BUILDING PERMIT

Located At 112 ELIZABETH RD

Job ID: 2011-08-2046-ALTR

has permission to Replace the front/ rear Porches and first floor Windows Only (Owner will Re-submit Plans for Dormer(s)/ Interior Renovations).

PORCH SECTION @ 1/2" SCALE

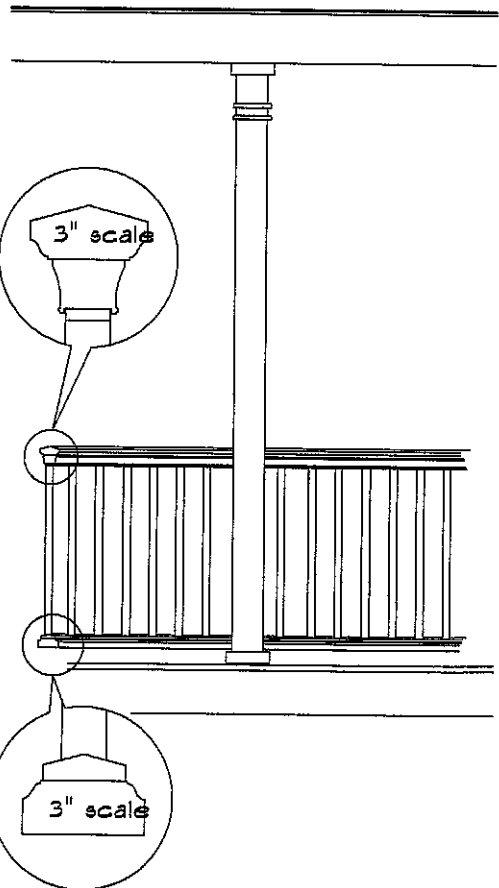
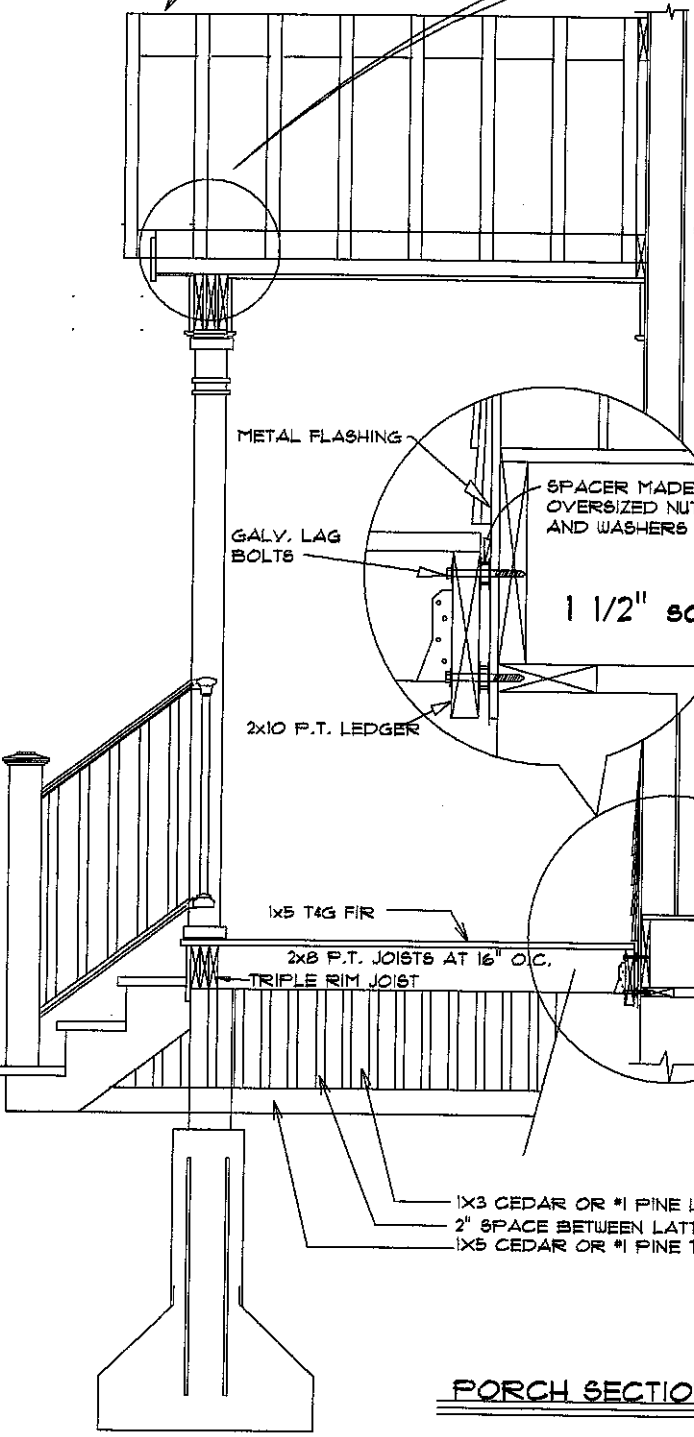
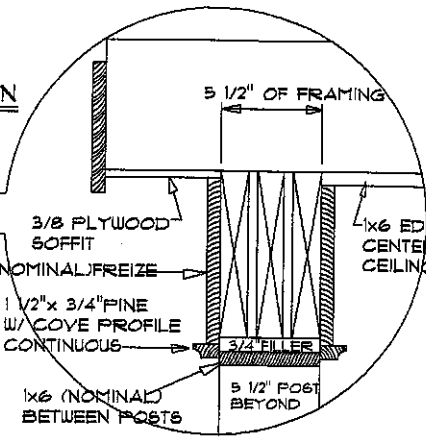
5. A graspable handrail (34-38 inches in height) shall be provided on at least one side of each continuous run of treads or flight with four or more risers. Fall protection (36 inches) from exterior decks may be required if floor joist are at or above thirty (30) inches from grade.

6. R312.3 Opening limitations. Required guards shall not have openings from the walking surface to the required guard height which allow passage of a sphere 4 inches in diameter.

7. **Note: Owner will utilize (2) 2 X12", (3) 2 X 10" or (4) 2 X 8" PT Beams for the 8-4" porch span between 8" Sona® Tubes; Finish Headroom of the proposed porch will be 7-0" minimum.**
